From: [REDACTED]
To: [Gatwick Airport](#)
Subject: Submission from Sussex Ramblers - Interested Party Reference number: 20044094
Date: 02 June 2025 10:28:29

In response to Gatwick Airport Ltd's letter of 24 April 2025, The Ramblers maintains its objection to the proposal for a second runway at Gatwick airport.

Permanent Diversion of 346_2Sy

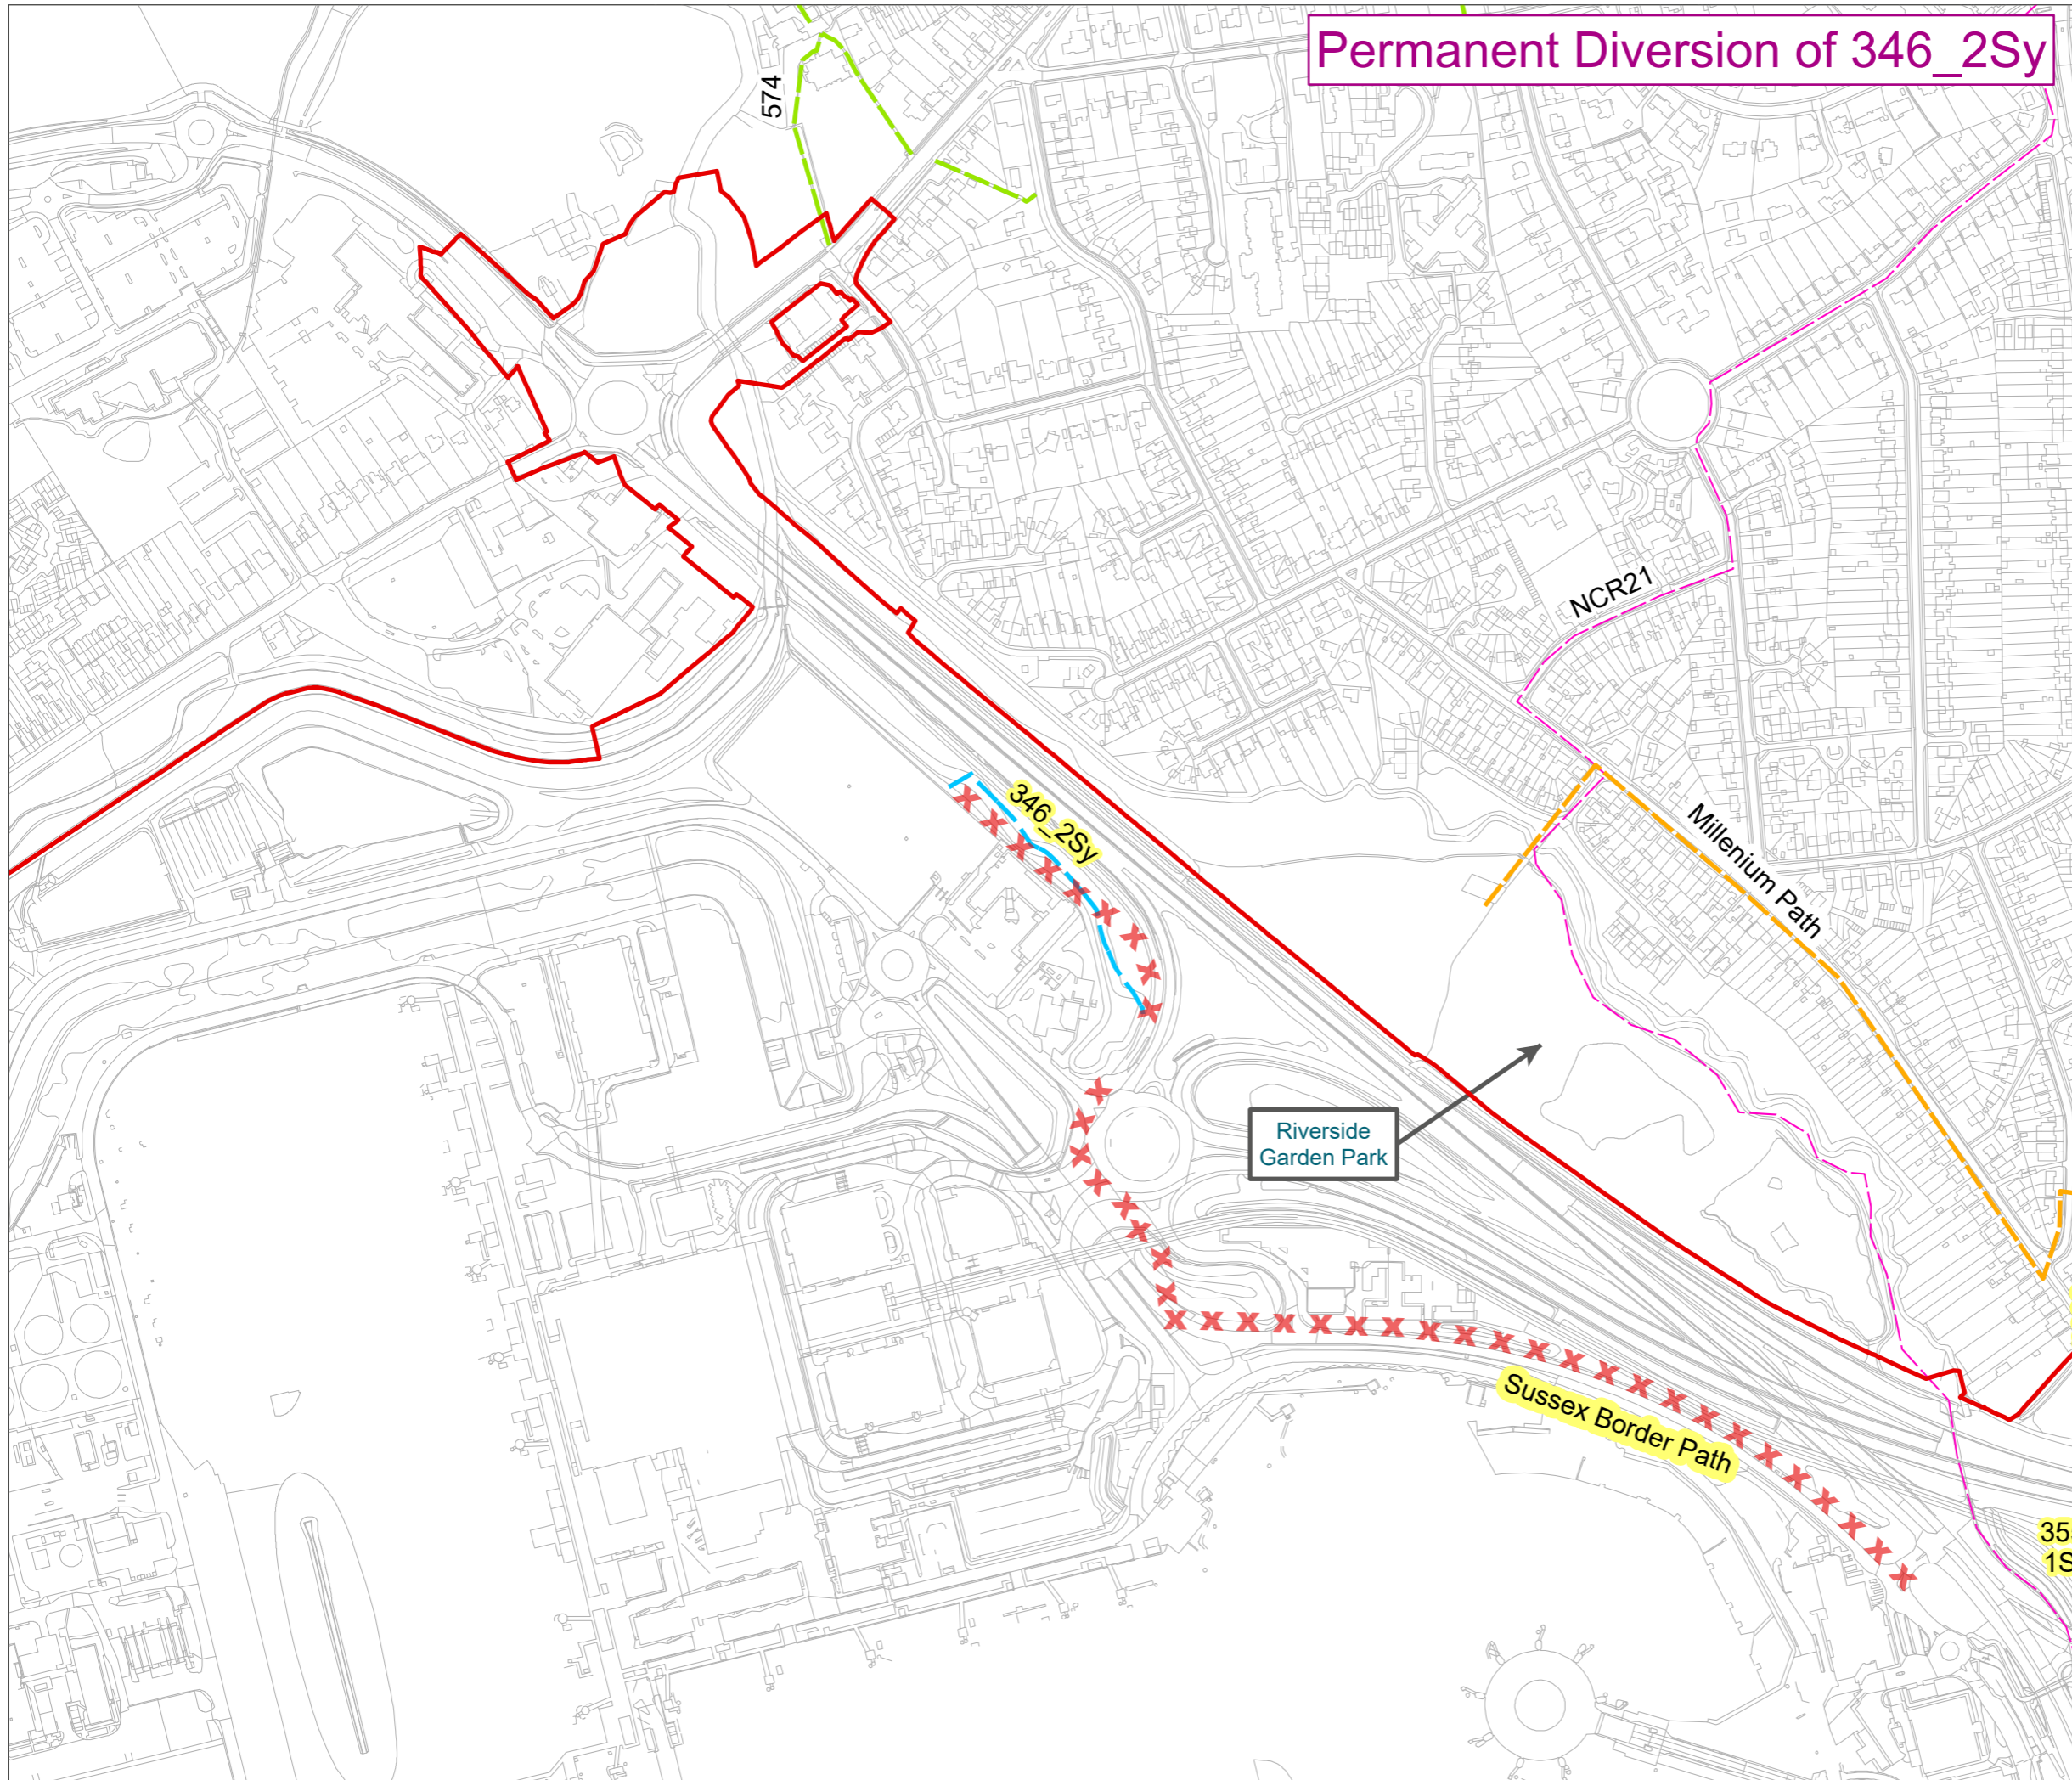
The permanent diversions of Footpath 346 / 2Sy are also unacceptable.

- Sharing it with National Cycle Route 21 means a loss of enjoyment and convenience for walkers, who must compete with cyclists.
- NCR 21 is itself to be temporarily diverted on to The Crescent, so more road walking again!
- And where NCR 21 rejoins its existing route, where's the continuation of the Sussex Border Path?

It is unclear where the permanent diversions will take the SBP and other paths when work is finally finished. We would expect to see Public Path Orders using Highways Act or Town & Country Planning Act to make the necessary changes to the path network. These include statutory rights of consultation, and possible objection by the public and organisations such as the Ramblers.
